# Bramford to Twinstead Reinforcement

Document 8.4.3 (B): Errata List

Final Issue B  
November 2023

Planning Inspectorate Reference: EN020002

Viewpoint F-02: View from the PRow to the North of Harrow Street

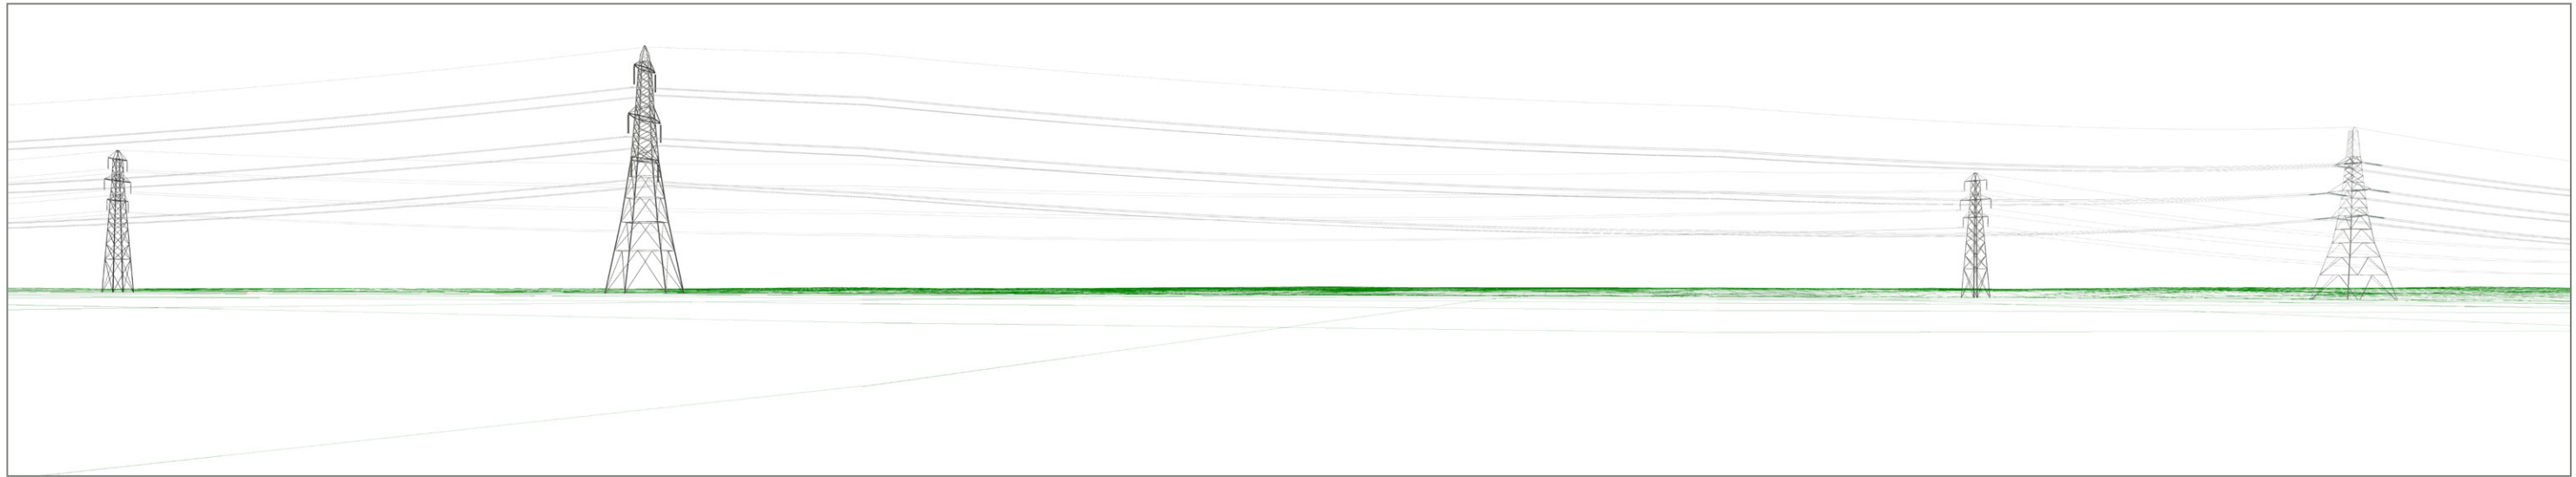
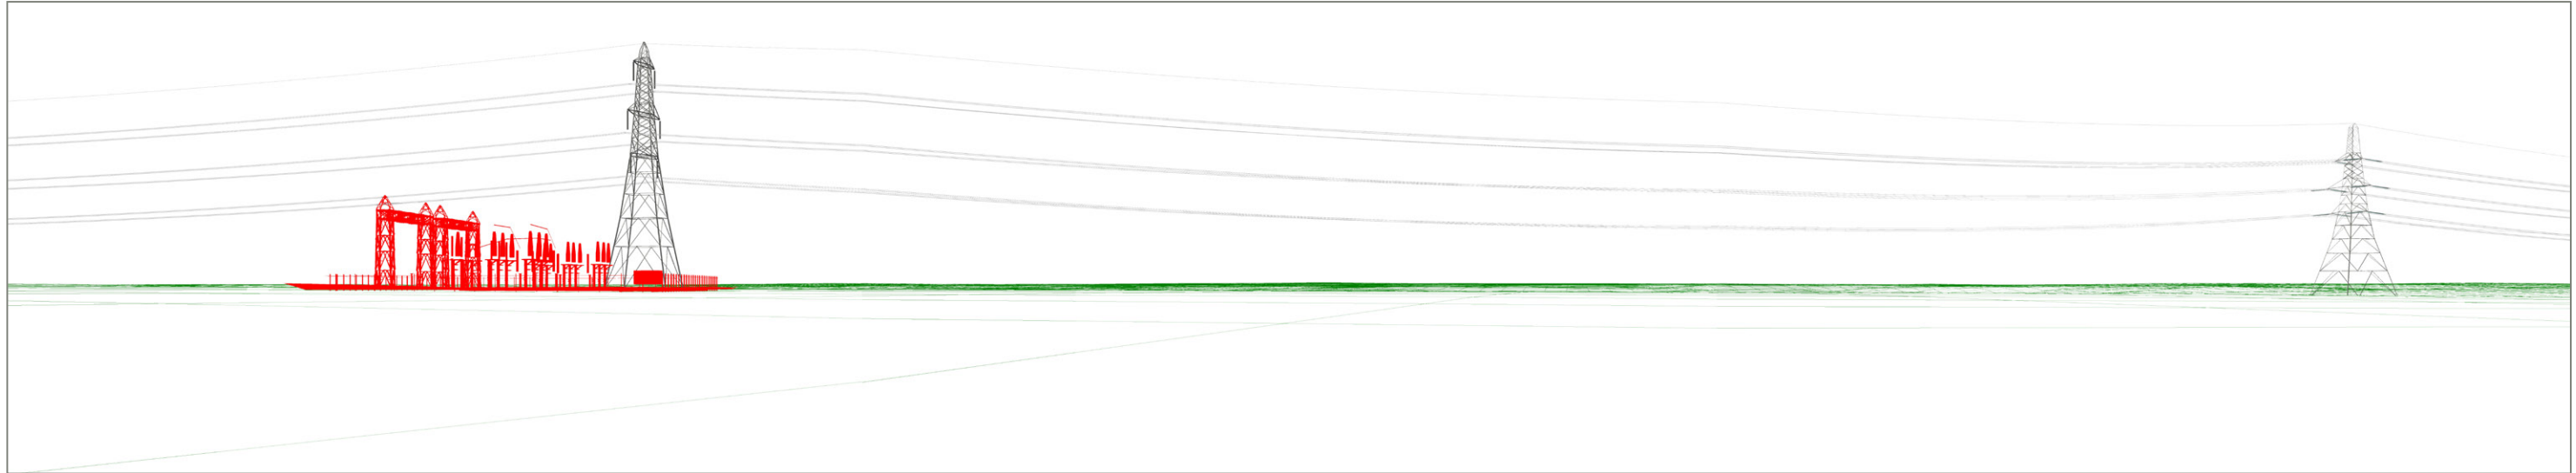
Document Number	Document Name	Paragraph / Section Reference	Nature of Erratum	Remedial Text, Reference or Narrative
				to the wireline and revision B has been submitted at Deadline 4.
[APP-105]	ES Appendix Viewpoint Assessment Section F Part 5	6.4 Wireline viewpoint F01	Error in the wireline of viewpoint F01	The pylon illustrated in the wireline showing the project was mistakenly illustrated as a suspension pylon. The pylon illustrated should have been a tension pylon. This correction has been made to the wireline and revision B has been submitted at Deadline 4.
[REP3-026]	CEMP Appendix A – Code of Construction Practice	GH07	The HRA Report was updated at Deadline 1 with the then current wording of GH07. However, the wording has been further updated following the Environment Agency's Written Representation [REP2-023] and this has been reflected in the CoCP which has been updated at Deadline 3 [REP3-026].	The following entry: is amended to read, 'A hydrogeological risk assessment will be undertaken once the trenchless crossing method has been confirmed. This will assess the risks on groundwater or surface water quality associated with the construction method including considering the potential for breakout during drilling and the use of bentonite or other agents proposed. Where the assessment identifies an unacceptable risk to groundwater or surface water quality, then alternative methods and/or additives shall be proposed, assessed and used. The hydrogeological risk assessment will be submitted to the Environment Agency for <del>information prior to construction approval</del> prior to construction. The Environment Agency will have up to 21 working days to respond on the hydrogeological risk assessment and their comments will be considered as part of finalising the risk assessment. This can be supported by a pre-submission draft to reduce the risk of any delays.'
